7 March 2019

FREEWAY NORTH SUBDIVISION (MP06_0199 MOD 2) BERESFIELD

I refer to your letter of 18 February 2019 advising Hunter Land Pty Ltd has submitted a Modification Request to modify the Concept and Project Approvals for the above development and inviting City of Newcastle ('CN') to comment.

Title: **SUBDIVISION PLAN**
 Address: **LOT 124 DP 1380583**
 Client: **HUNTERLAND**

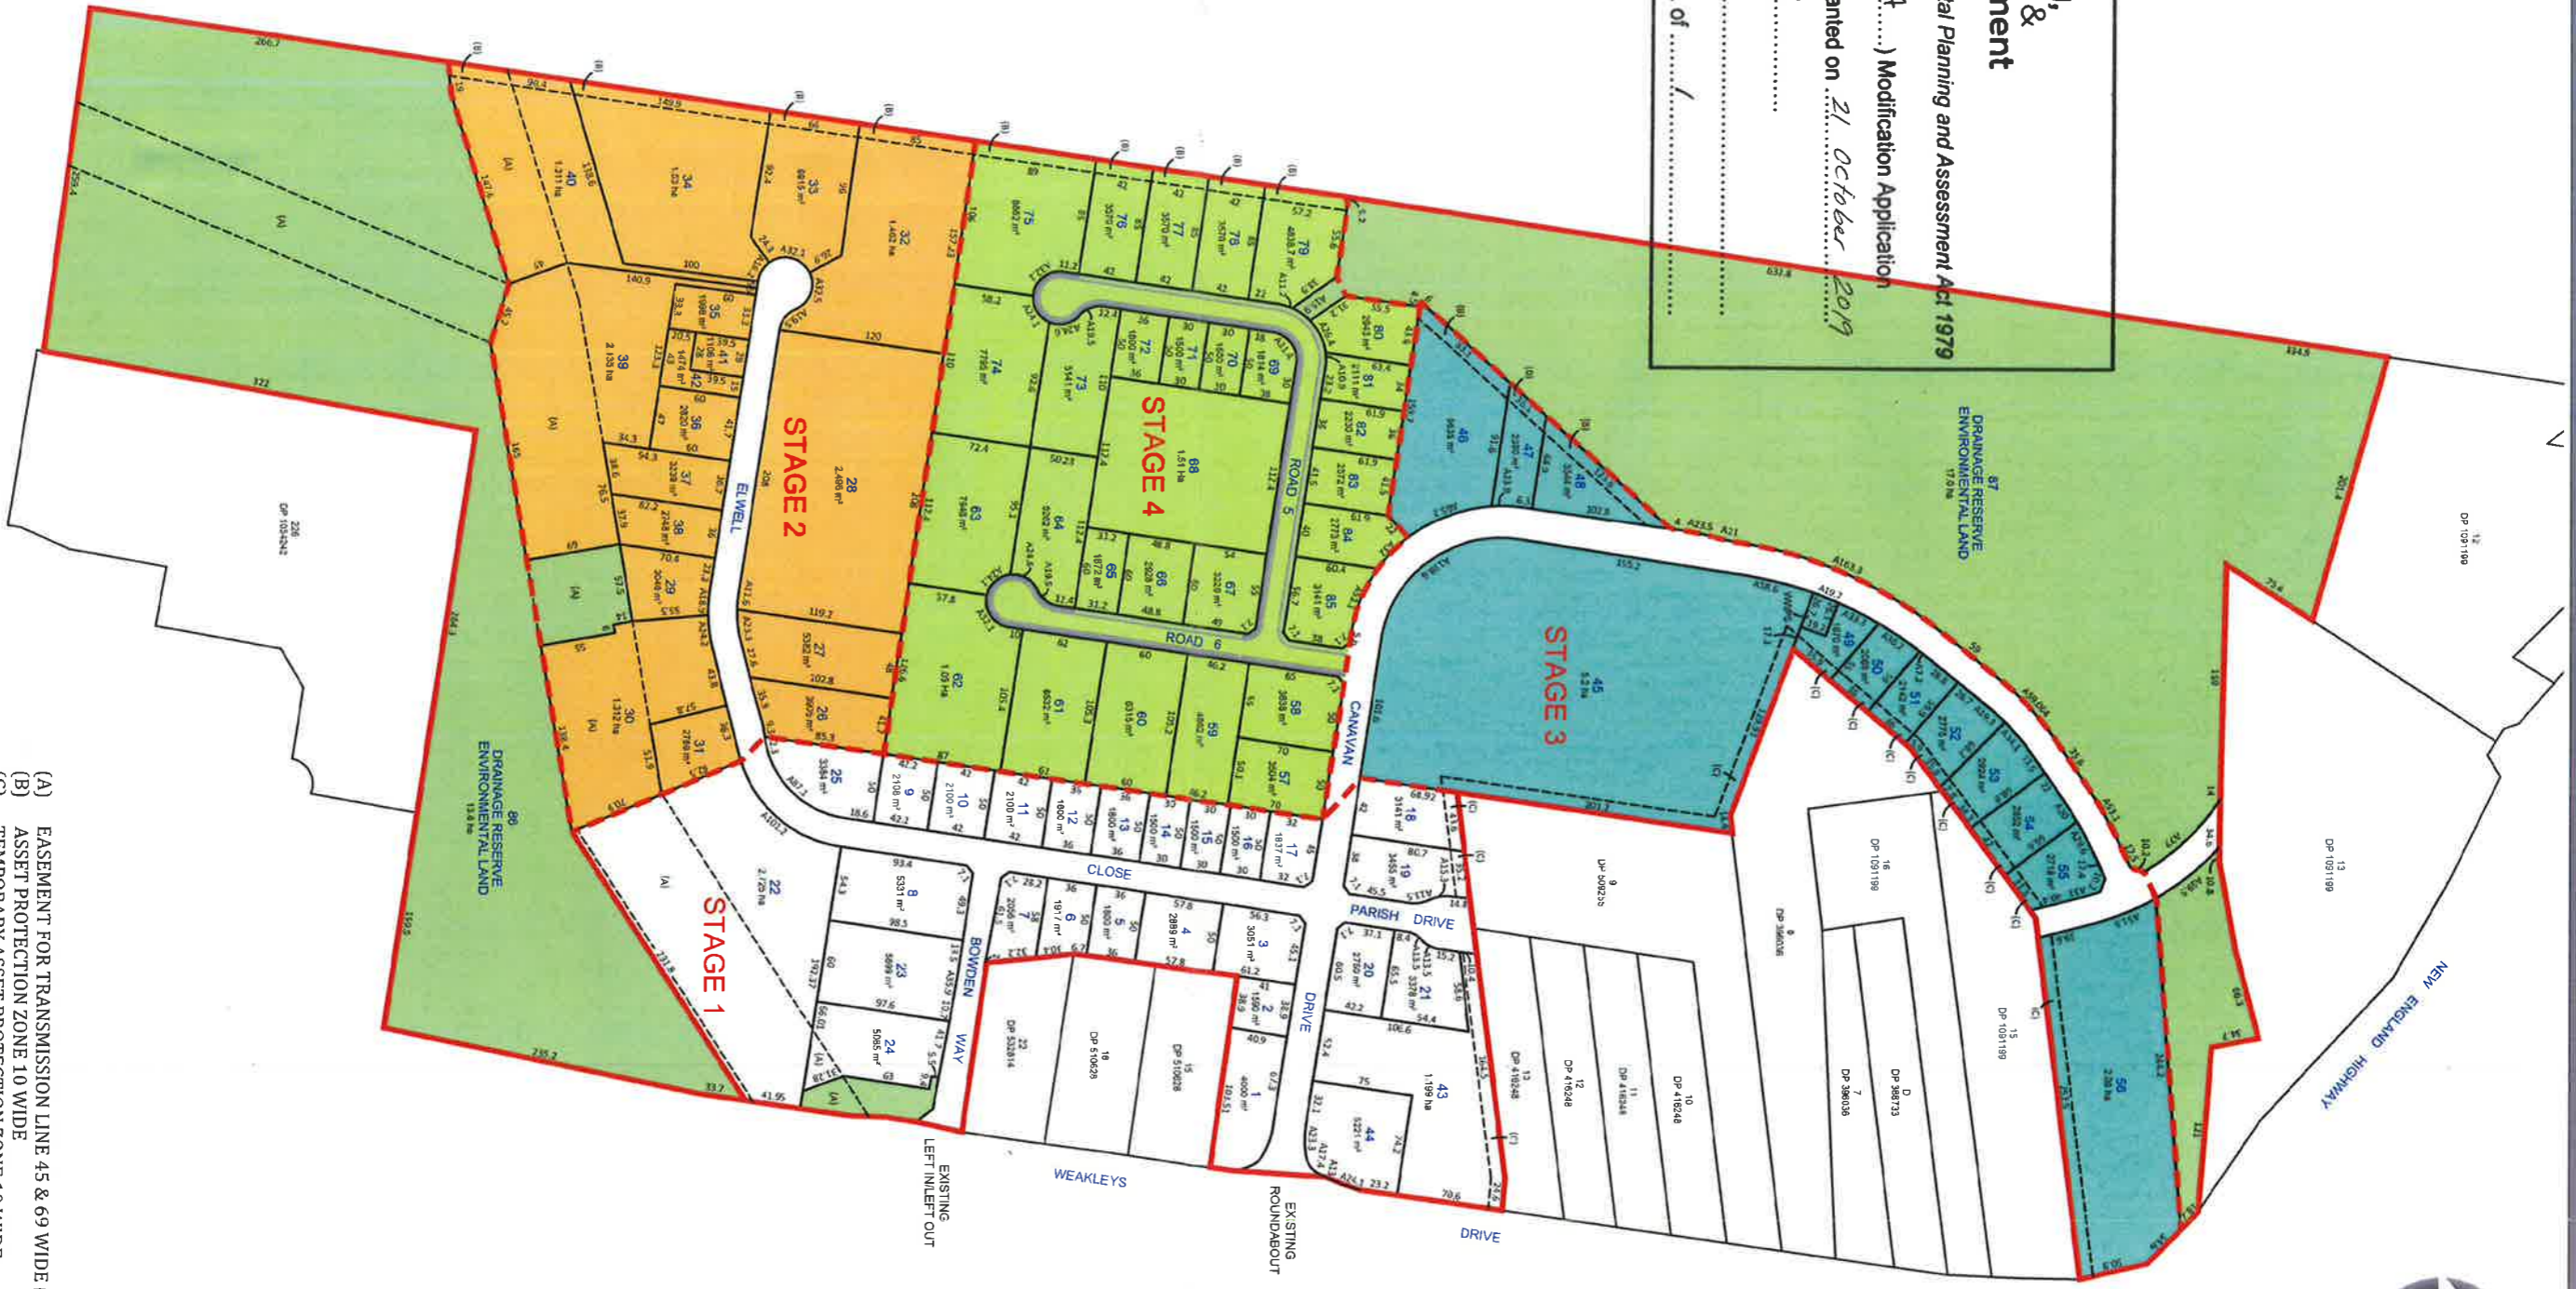
The submitted cover letter dated 23 January 2019 prepared by Hunter Land states it is proposed create 20 industrial lots from the subdivision of Lot 124. The plan of proposed subdivision prepared by Delfs Lascelles (Ref. 17010 Dwg 1 Rev 2 dated 7/12/18) provides no details of the proposed subdivision layout other than indicative proposed boundaries. Therefore, there is no way of determining if the lots and roads proposed will comply with the relevant requirements of the Newcastle Development Control Plan 2012. The Department is encouraged to confirm these details as part of its consideration of the s75W and SSD applications. Also, contrary to the advice provided in the Hunter Land letter the indicative subdivision layout by Delfs Lascelles shows 30 proposed industrial lots and associated roads.

If the Concept and Project approvals were amended to remove a reference to a specific maximum intended lot yield then there would be no restriction on the subdivision of Lot 124 to create lots meeting CN's minimum lot area of 1,000m². Allowing say 15,000m² for road reserves (as shown) this could result in around 135 lots (@ 1,000m²/lot). This resulting scenario is not consistent with the original Concept Plan approval and the Department is encouraged to maintain some level of control in the Concept Plan to guide the preferred fully developed outcome for this development. In this regard, the applicant has not

addressed the impact of the proposed modification on Condition A5 of Schedule 2 which, in part, allows the consolidation of lots and the adjustment of boundaries between lots but only where this does not involve the creation of a greater number of lots. This suggests that the Minister, in addition to the prescriptive number of lots in Condition A1 of Schedule 2 and Condition A1 of Schedule 4, sought to control the maximum number of lots to be created within the bounds of the Concept Plan. Given these circumstances, the inclusion of these prescriptive limits was not an error on the Minister's part as suggested by Hunter Lands.

- The original Concept Plan and Project Approval layouts showed interconnecting roads in lieu of the two proposed cul-de-sacs which funnel all associated traffic through the single intersection with Canavan Drive. While the proposed intersection with Canavan Drive appears to be well located, the applicant should be requested to produce a summary Traffic Impact Assessment of the anticipated traffic generated by these industrial lots and provide advice on the adequacy of this single intersection to cope with the anticipated demand without additional intersection controls. In this regard, CN has recently been approached by occupants of the Freeway South Business Park, who are in a similar situation to that now proposed where three cul-de-sacs all contribute to a single intersection with the main collector road. It is alleged by the users they are at times having trouble finding enough gaps in the crossing traffic flows to enable safe and timely egress from the minor road.
